City of Albuquerque
Planning Department
Inter-Office Memorandum

SUBJECT: Project # 1009234

On July 12, 2012, the Environmental Planning Commission approved Project # 1009234, 12EPC-40032, a request for an amendment to a site development plan for building permit for all or a portion of Lot 2C, St. Joseph Hospital Complex, zoned SU-1 for Hospital & Related Uses & Hotel, located on High Street, between Lomas Boulevard and Fruit Avenue, containing approximately 3.2 acres.

Sheet Title:
Landscape
Plan

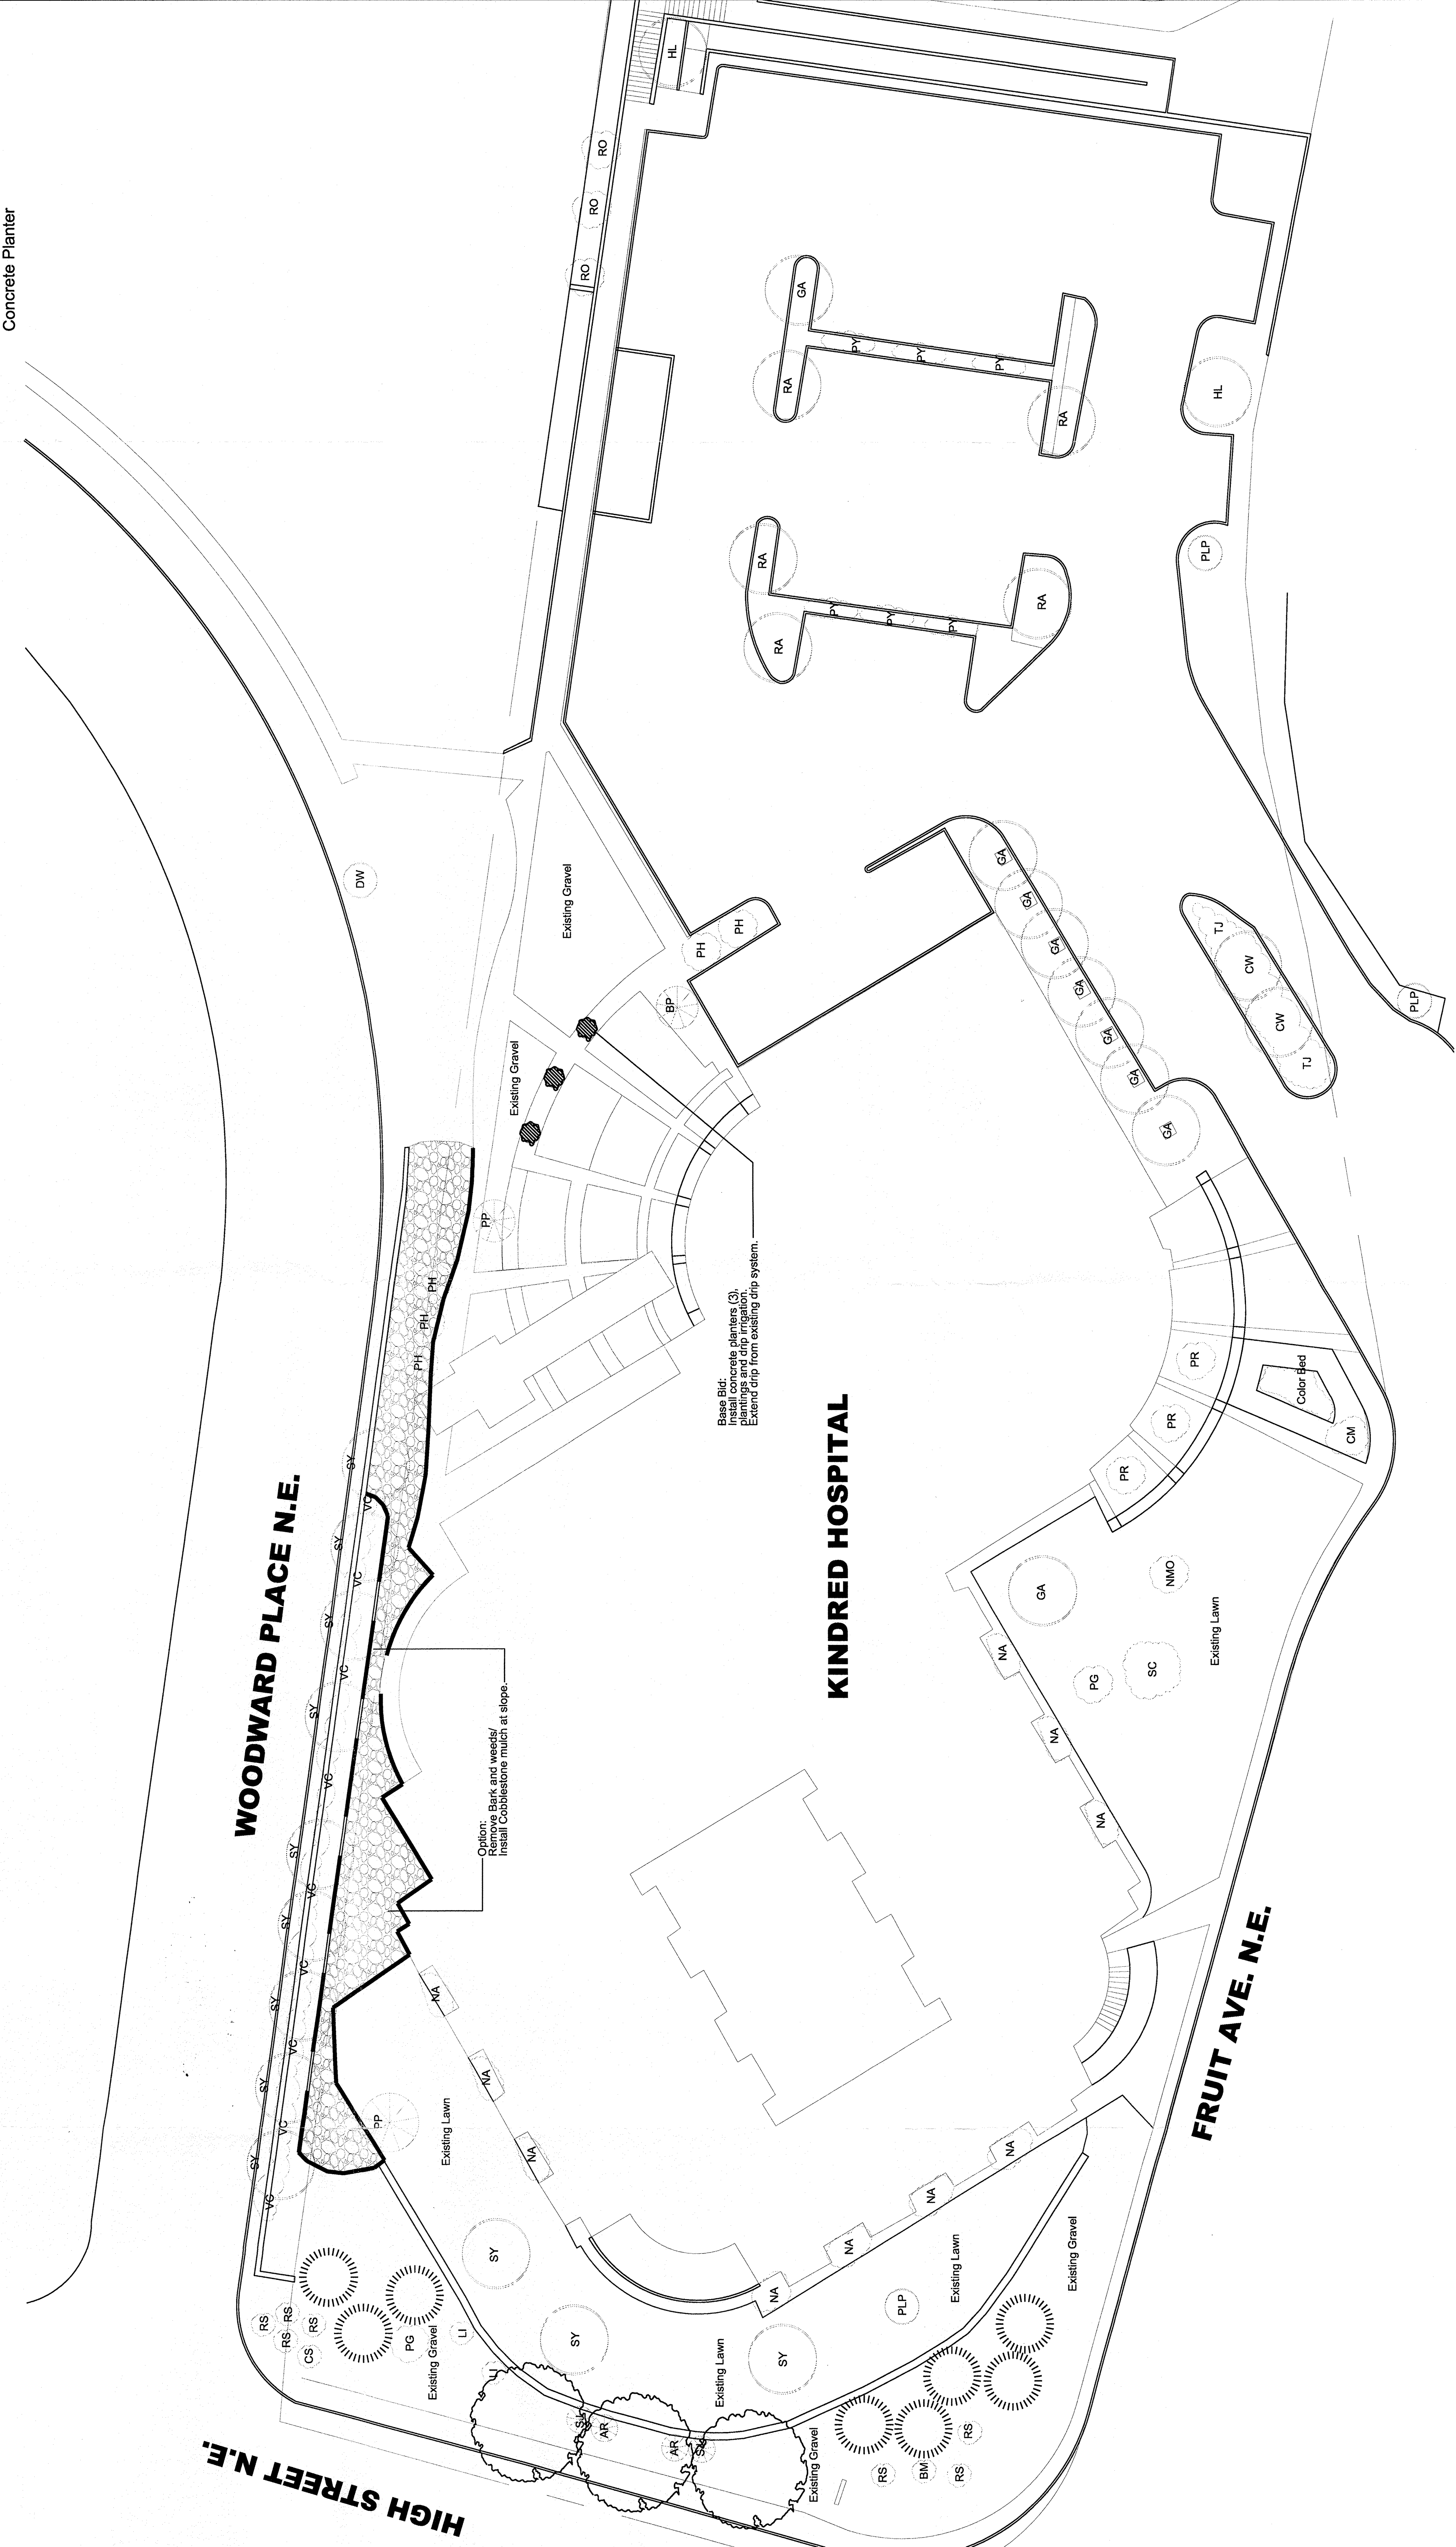
3a. Additional landscaping (which shall consist of a combination of trees and bushes that are consistent with the existing landscaping on the St. Joseph Medical Center Campus and Kindred Hospital and that preferably are low water use) shall be added to help screen the oxygen tanks and the mobile CT scanner from the properties to the north.

Applicant has stated that they cannot plant landscaping within 25 feet of the oxygen tanks because any live material within a 25 foot radius is combustible. North of the oxygen tanks (approximately 35 feet) there is available land to place landscaping; however, this is not part of the applicant's property, and is City right-of-way. Applicant has stated that they would be willing to plant and maintain landscaping in this City ROW and provide an irrigation system. Applicant would like to come to an agreement with the City to be able to use the City ROW in order to meet this condition of approval. Applicant is proposing to plant 3 Chinese Pistache trees in the City ROW.
